Agency Review Comments

Trails at Aspen Ridge #2

EA-16-105

SF1927

**THE TRAILS AT ASPEN RIDGE FILING NO.2**  
A SUBDIVISION OF A PORTION TRACT Q AND TRACT R OF THE TRAILS AT ASPEN RIDGE FILING NO.1  
LOCATED IN THE WEST 1/2 OF SECTION 9,  
TOWNSHIP 15 SOUTH, RANGE 65 WEST OF THE 6TH P.M.  
EL PASO COUNTY, COLORADO  
SHEET 4 OF 4

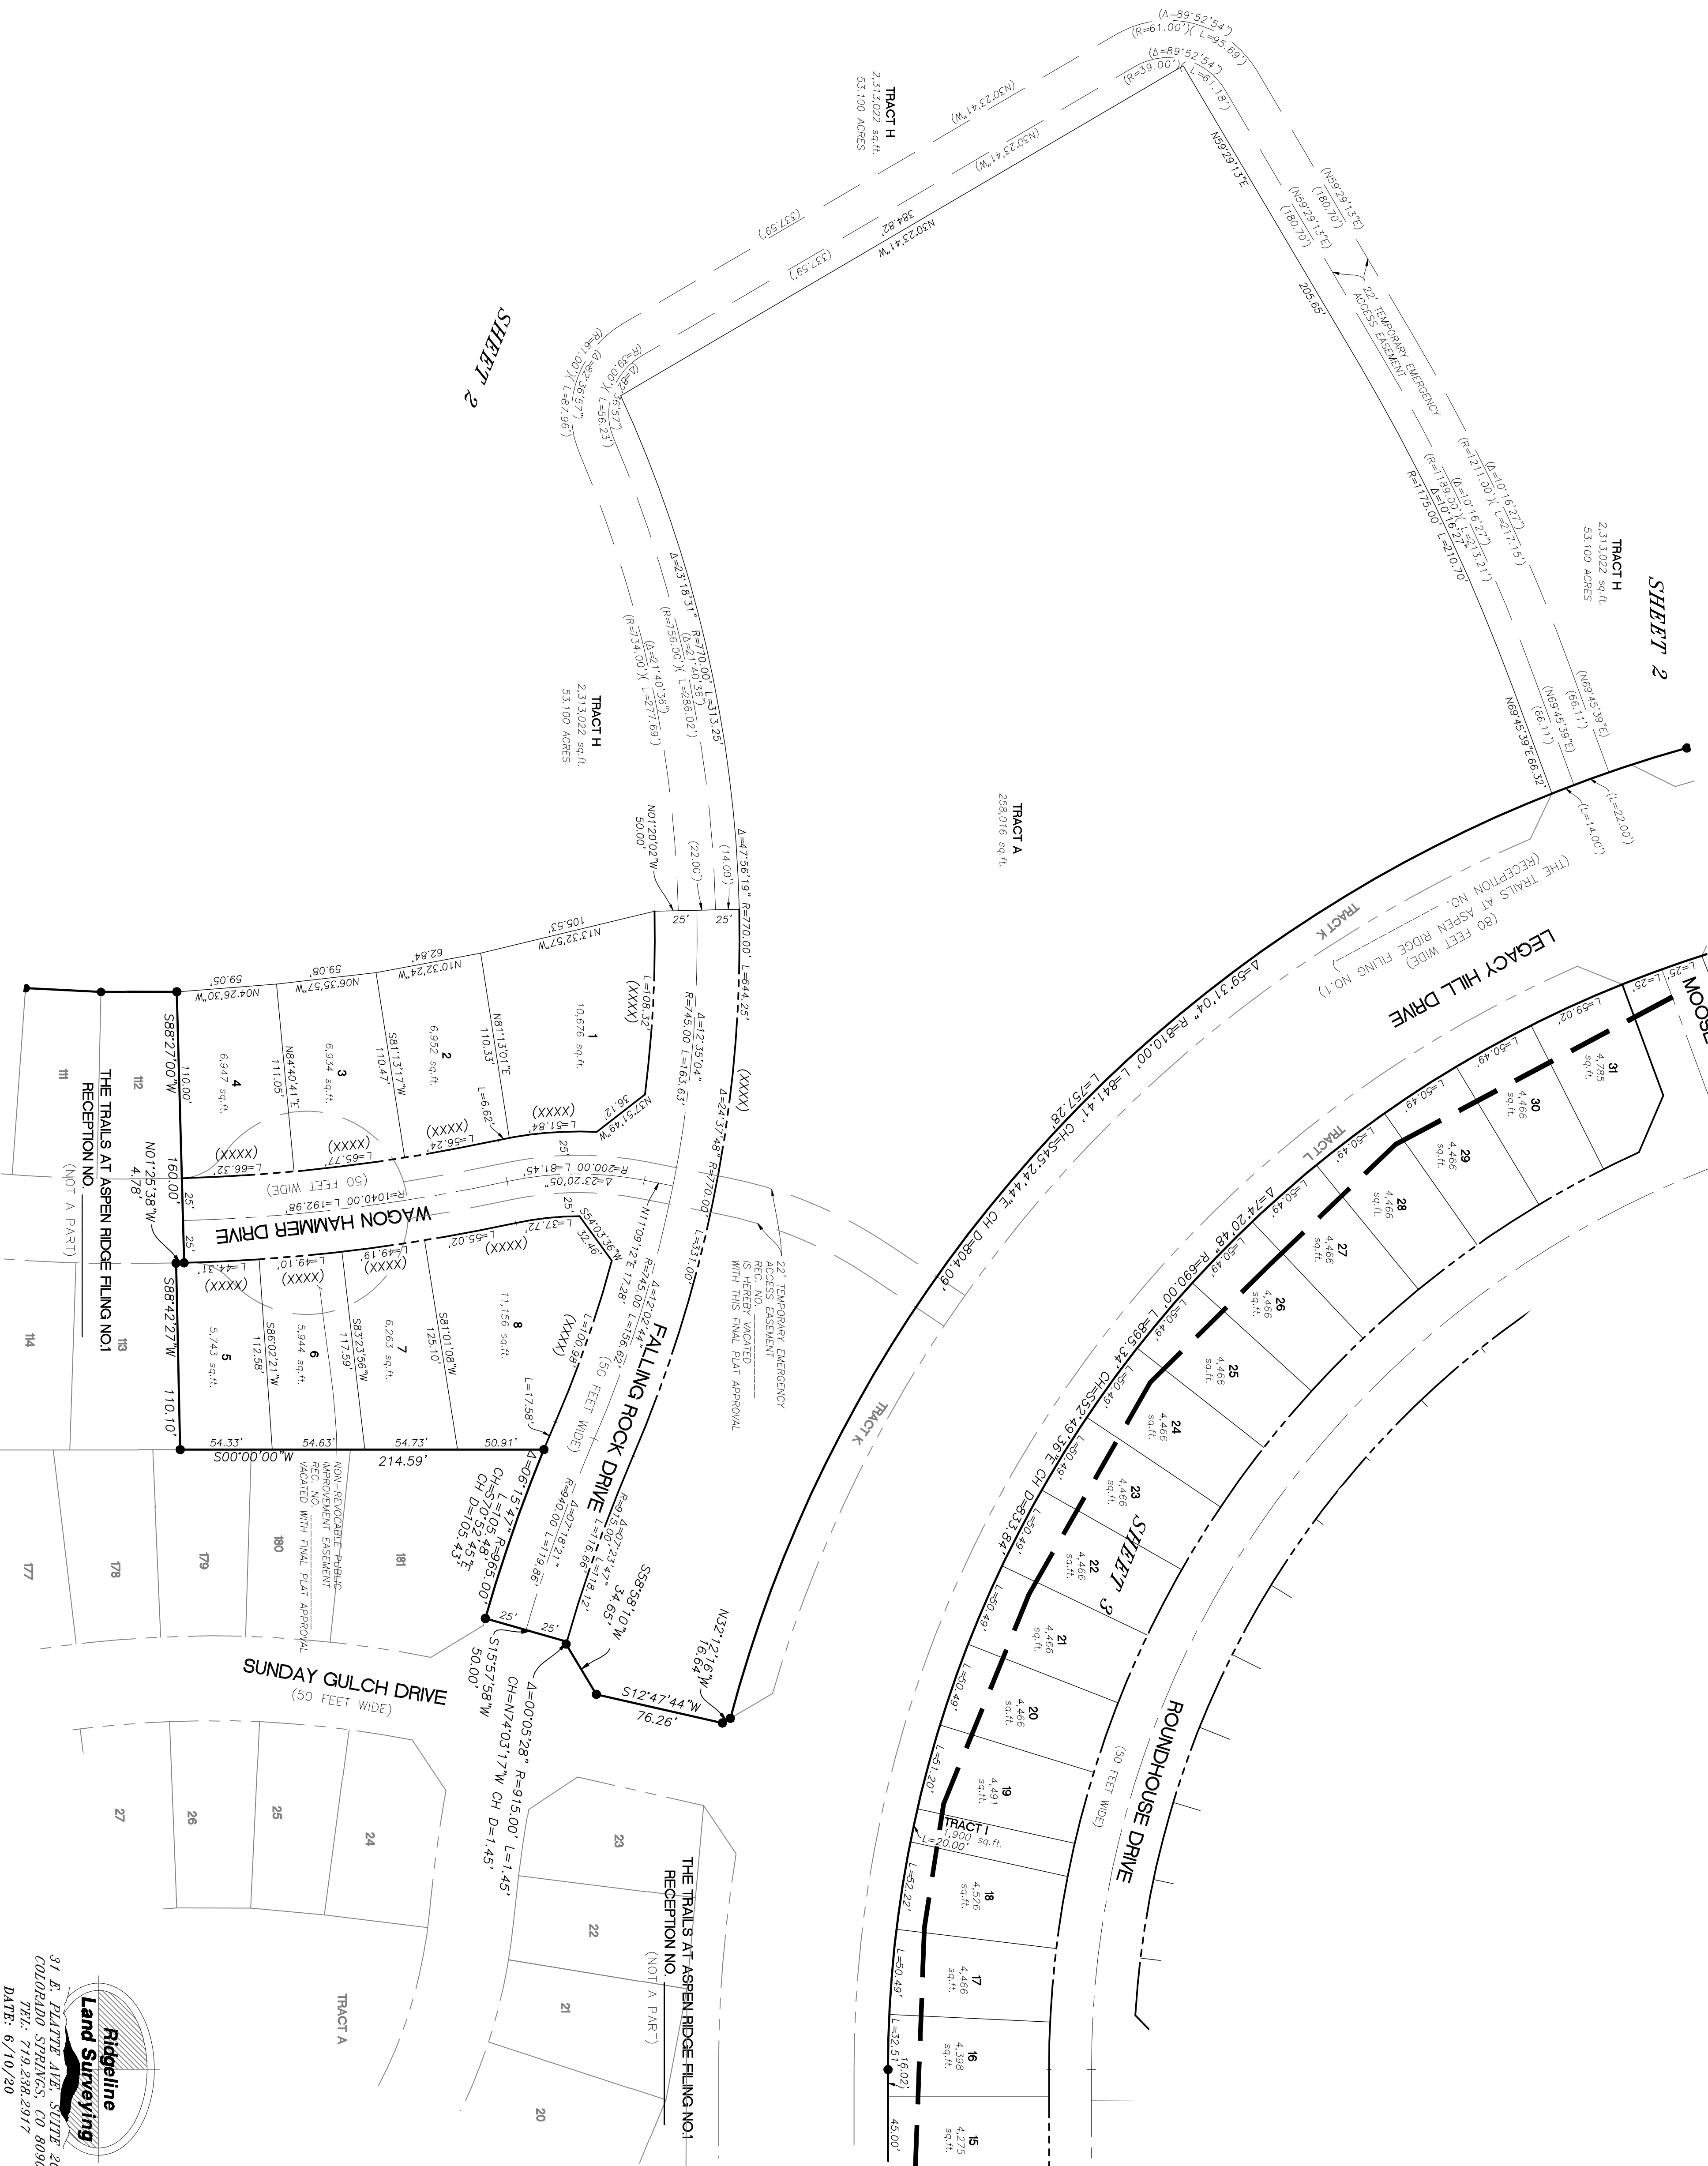
Pikes Peak Regional Building Department	Regarding a request for approval of a final plat for The Trails at Aspen Ridge Filing No. 2, Enumerations has the following comments: 1. One of the street names shown on this plat, Nutterbutter Point, is on the list of approved street names sent to us by Justin Annan at El Paso Teller 911. However, the street suffix Point is used to designate private streets, not public ones. Verify with Justin that the use of this suffix is OK, or if it should be changed to a suffix used to designate public streets such as Drive, Street, or Road. 2. Submit a copy of this plat to Enumerations for addressing. Show the location of the front doors for the houses on each lot, particularly Lots 32-44 and 63-70 where there is a street on both sides of the lots. 3. Plat note 12 states that there is no direct access to Legacy Dr., but, the street name is shown as Legacy Hill Dr. Correct the plat note to show the correct street name. 4. Enumerations will review the mylar prior to plat for address placement, street names, and title block. Noted. Thank you. 5. \$10.00 per lot & tract platting fee will be due at the time of the review of the mylar (2 addresses per lot & tract). If an address is not needed on a tract then no fee applies. Check should be made out to PIKES PEAK REGIONAL BUILDING DEPARTMENT or PPRBD. Paid directly to the Enumerations Department. Noted. Thank you. 6. A copy of the final recorded plat is required prior to plan submittal for RESIDENTIAL. A copy of the final recorded plat is required prior to approval in the Enumerations department on any COMMERCIAL plan submittal. Amy@pprbd.org or Brent@pprbd.org Brent Johnson Enumerations Plans Examiner Pikes Peak Regional Building Department O: 719-327-2888 E: brent@pprbd.org W: pprbd.org	12/30/2019 9:02:38 AM Nutterbutter Point is a private street. This has now been indicated on the plat. Street name has been corrected on the plat Noted. Thank you.

Panel Location Map

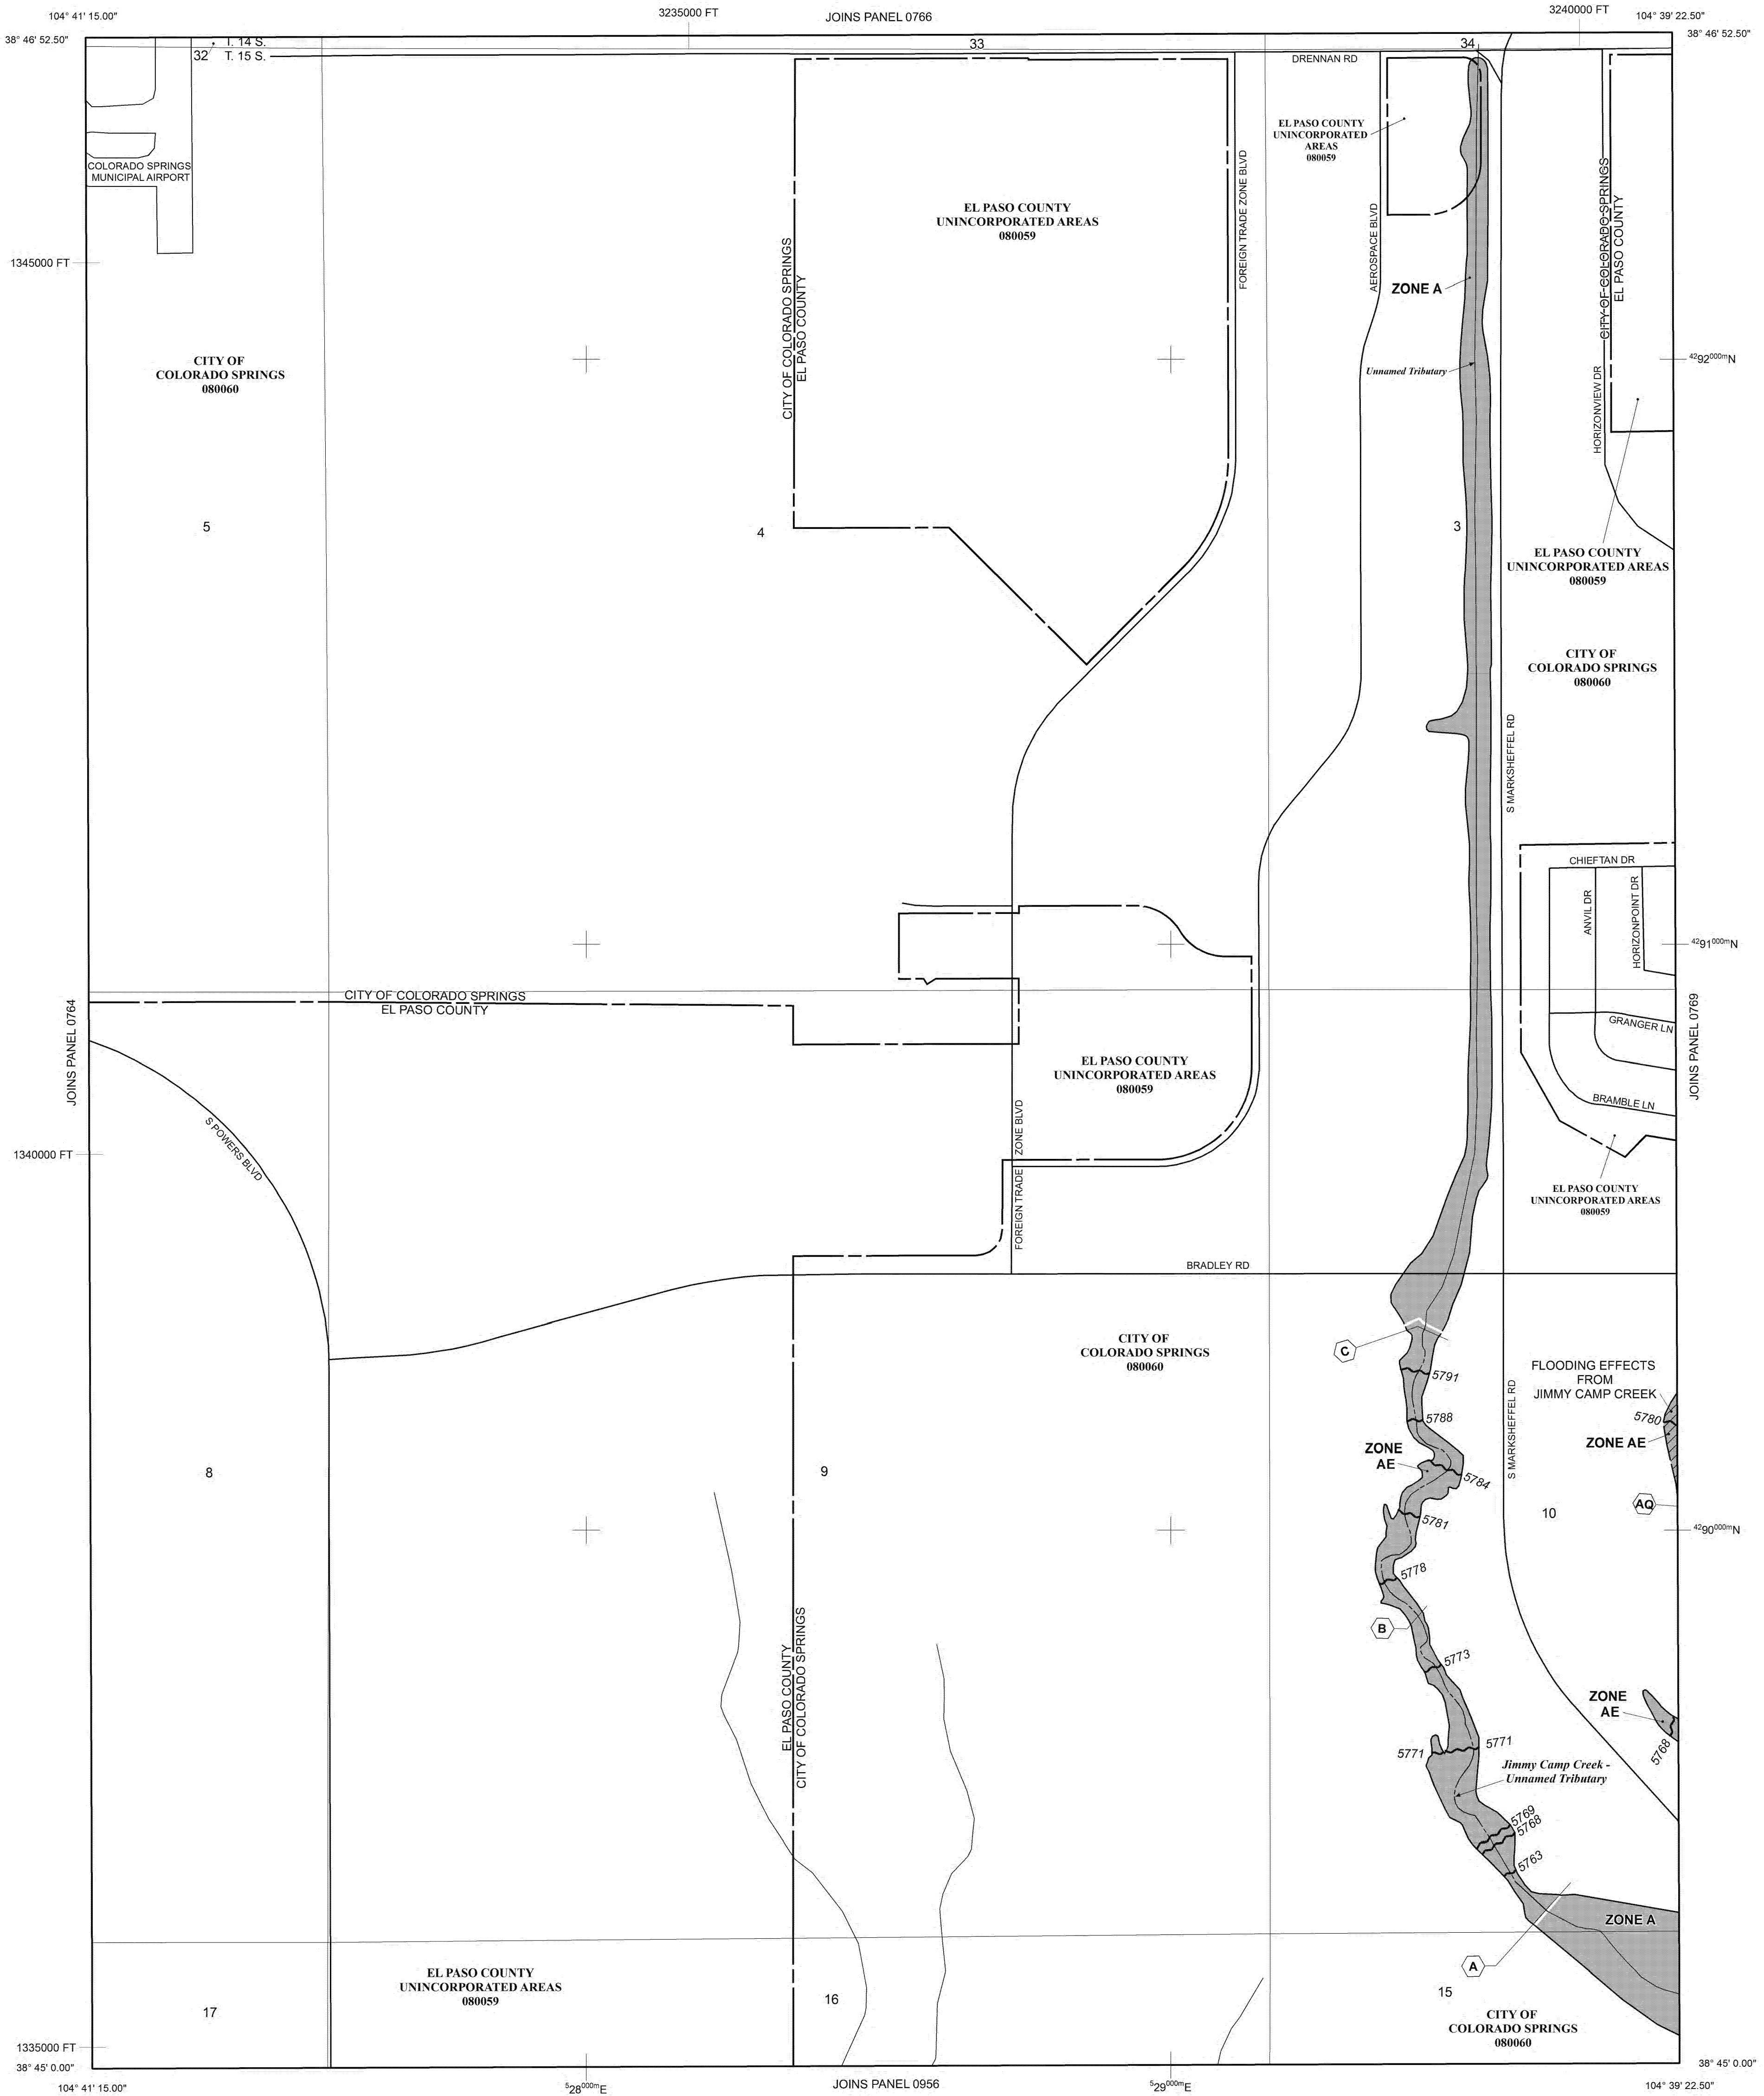
RBD Floodplain	FIRM date is dec 7th not 12th	12/11/2019 10:04:06 AM
RBD Floodplain	Floodplain note: Date for the FIRM is December 7th 2018, not 12th	12/11/2019 9:59:56 AM
County Attorney - Development Review	<p>1. Please complete and provide a Subdivision Improvements Agreement and a Private Detention Basin/Best Management Practices Agreement, both in Word, for review.</p> <p>2. If the applicant wishes to include the subdivision in a Public Improvement District for the purpose of partial payment of the Road Impact Fee, please submit a signed and notarized petition for PID 2 or PID 3 along with a legal description of the entire subdivision in Word. PID inclusion must occur before the plat is recorded. The inclusion petition must be heard by the BoCC at a public hearing. The County Attorney's Office will attempt to schedule the inclusion hearing on the same day or as soon thereafter as possible as the BoCC hearing or administrative decision on the final plat. State law requires that notice of the inclusion hearing be published for 3 consecutive weeks prior to such hearing. The applicant is responsible for reimbursing the County Attorney's Office for the cost of such publication. The applicant and the County planner are responsible for advising the County Attorney's office of the final plat hearing or decision date at least one month in advance, so that the required publications can be completed in time.</p>	12/10/2019 10:27:55 AM
